Development Control
Ribble Valley Borough Council

Your ref: 23.0877
Our ref: D3.23.0877
Date: 14th November 2023

App no: 23.0877

Address: Land adjacent to Bonny Barn Pasture Belle Vue Lane Waddington

Proposed field access layout  
Twitter Lane  
Scale 1:300 @ A3

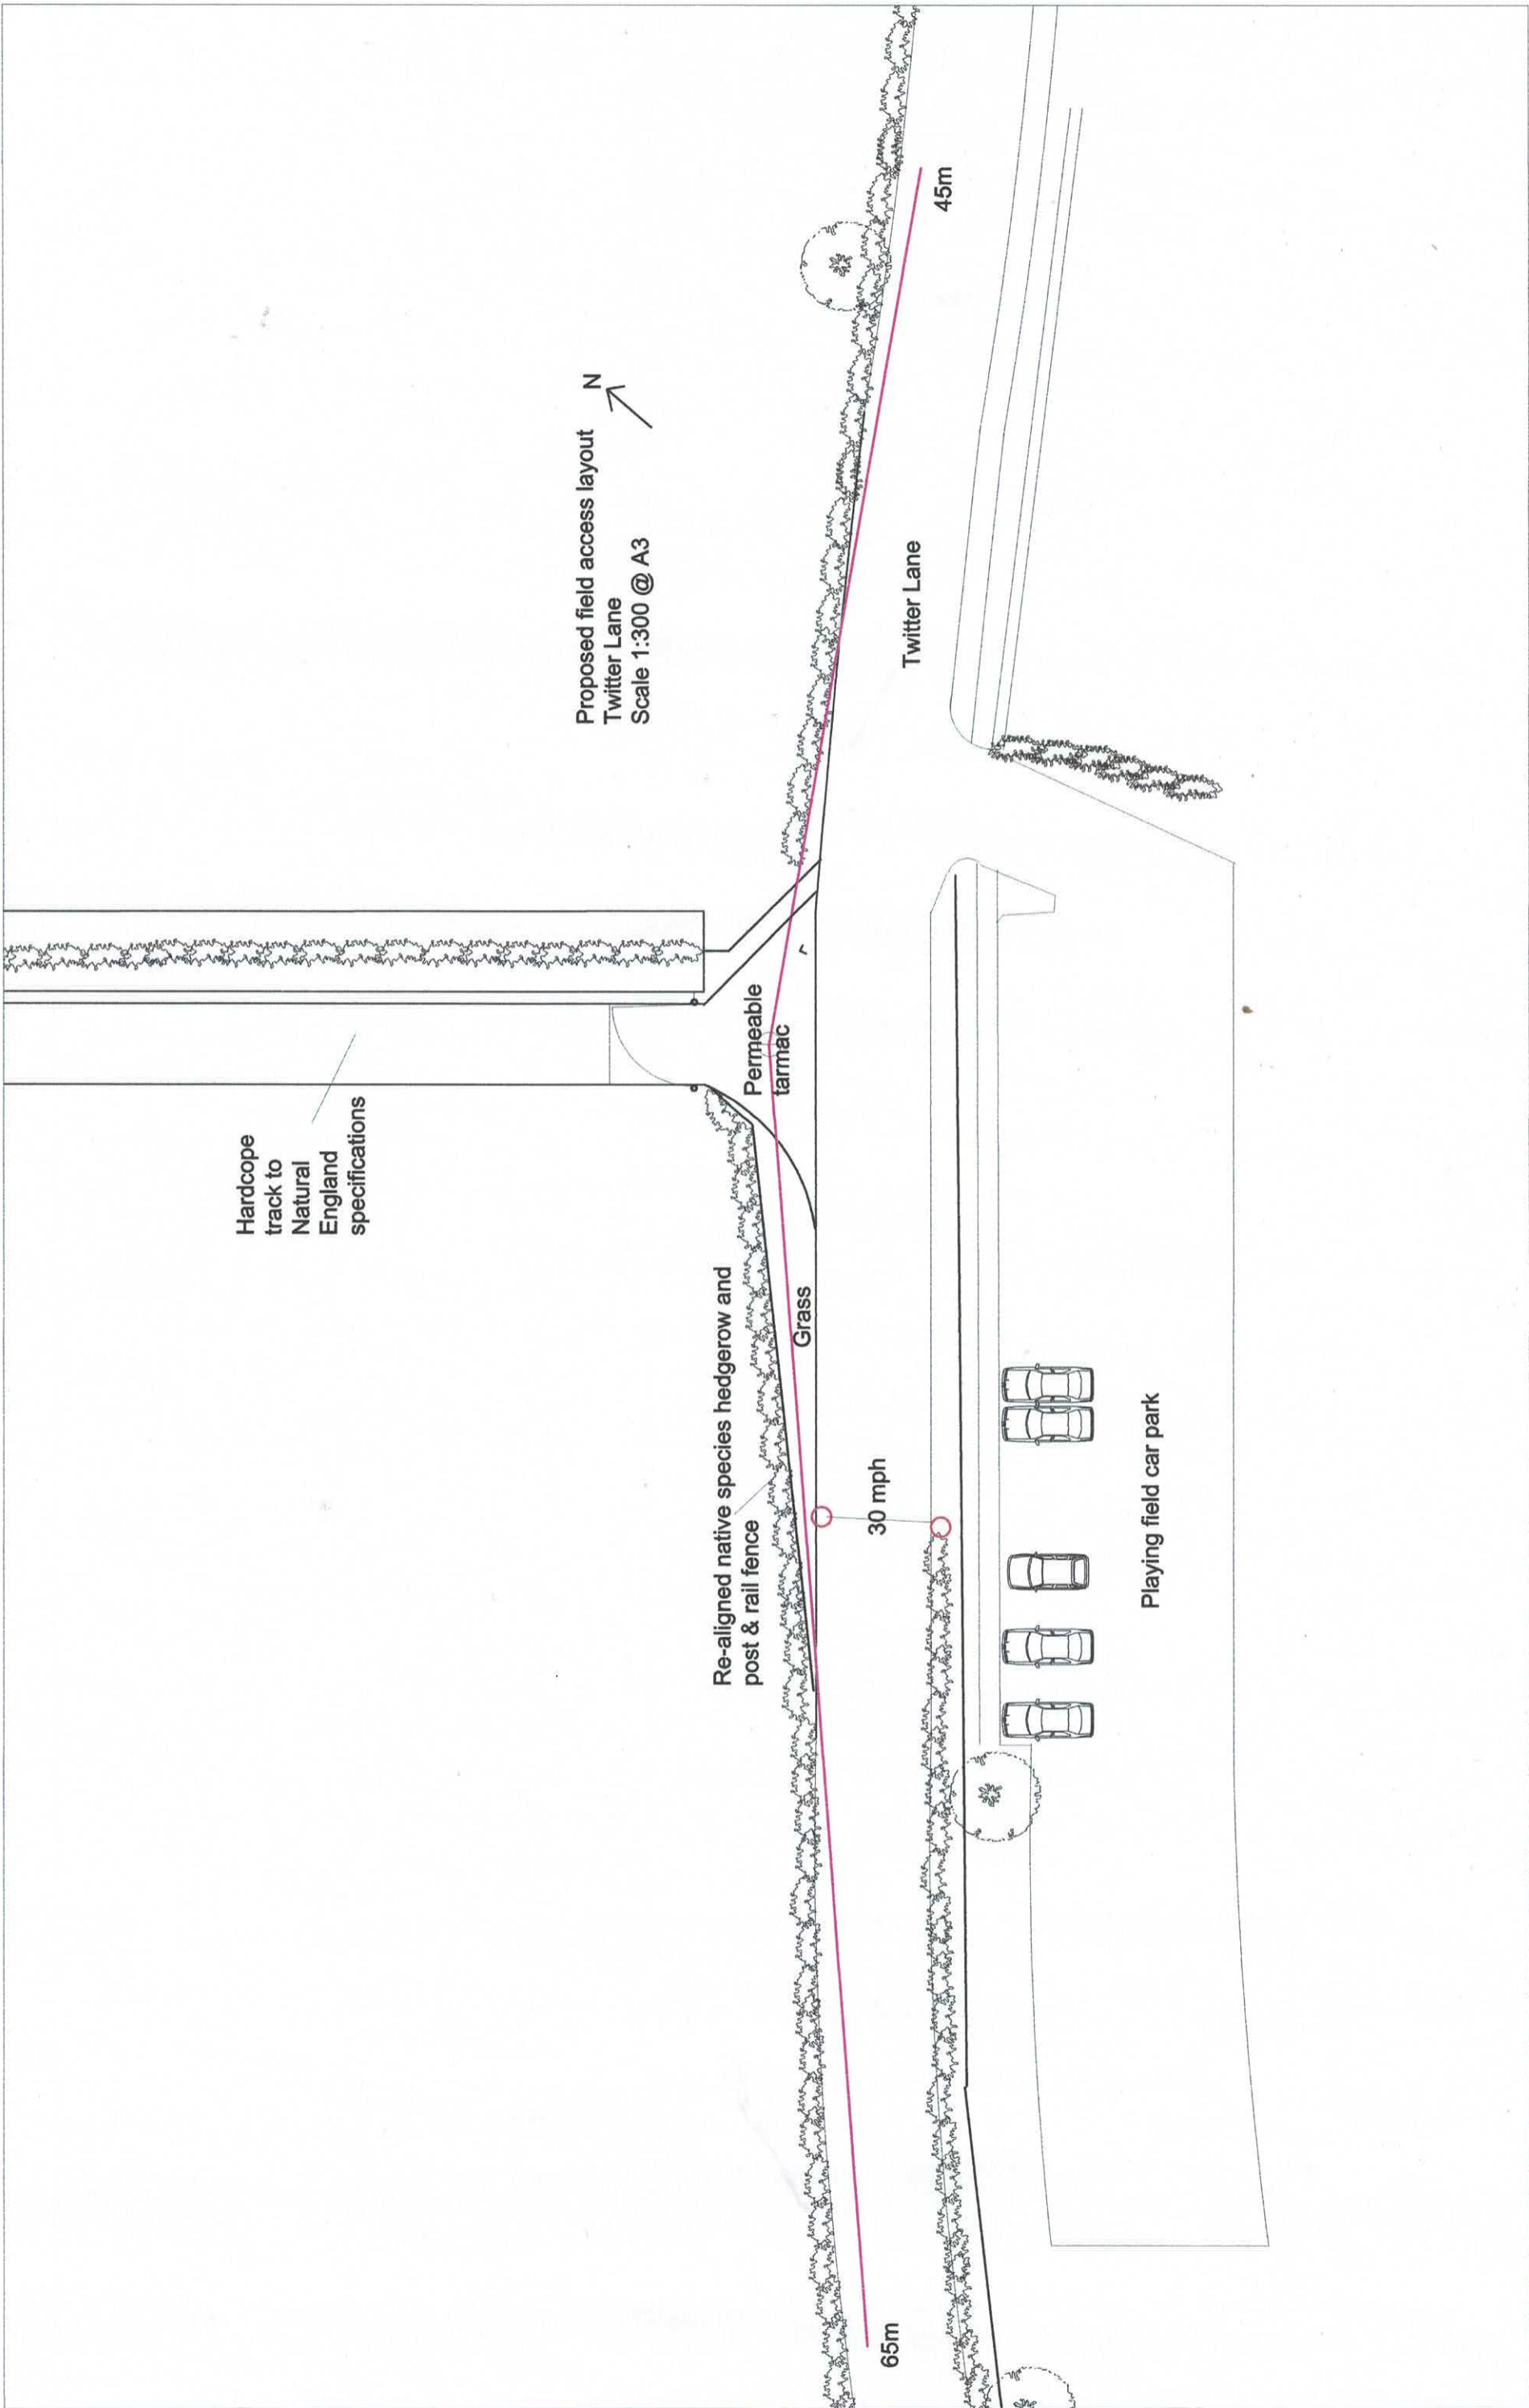
There are access improvements proposed at the Twitter Lane field gate which include setting the gates back by 10m from the edge of Twitter Lane, paving the surface between the gates and Twitter Lane with a porous bound material and setting back the hedge to provide a visibility splay to the southwest side of the access by X2.4m by Y33m.

We would request that further measures should be provided at the site access to include visibility splays to both sides of the site access along Twitter Lane to provide splays of X2.4m by Y43m to both sides. The hedgerows can be set back along the splay line or left in situ and kept trimmed below 1m high.

1. Notwithstanding the provisions of the Town and Country Planning (General Permitted Development) Order 1995 there shall not at any time in connection with the development hereby permitted be erected or planted or allowed to remain upon the land hereinafter defined any building, wall, fence, hedge, tree, shrub or other device over 1m above road level. The visibility splay to be the subject of this condition shall be that land in front of a line drawn from a point 2.4 m measured along the centre line of the proposed site access from the continuation of the nearer edge of the carriageway of Twitter Lane to points measured 43m to both sides of the site access along the carriageway of Twitter Lane, from the centre line of the access. Reason: To ensure adequate visibility at the site access.

2. The site access shall be paved in a bound and porous material with gates set back by at least 10m from the carriageway of Twitter Lane prior to first use of the site access. Reason: For highway safety.
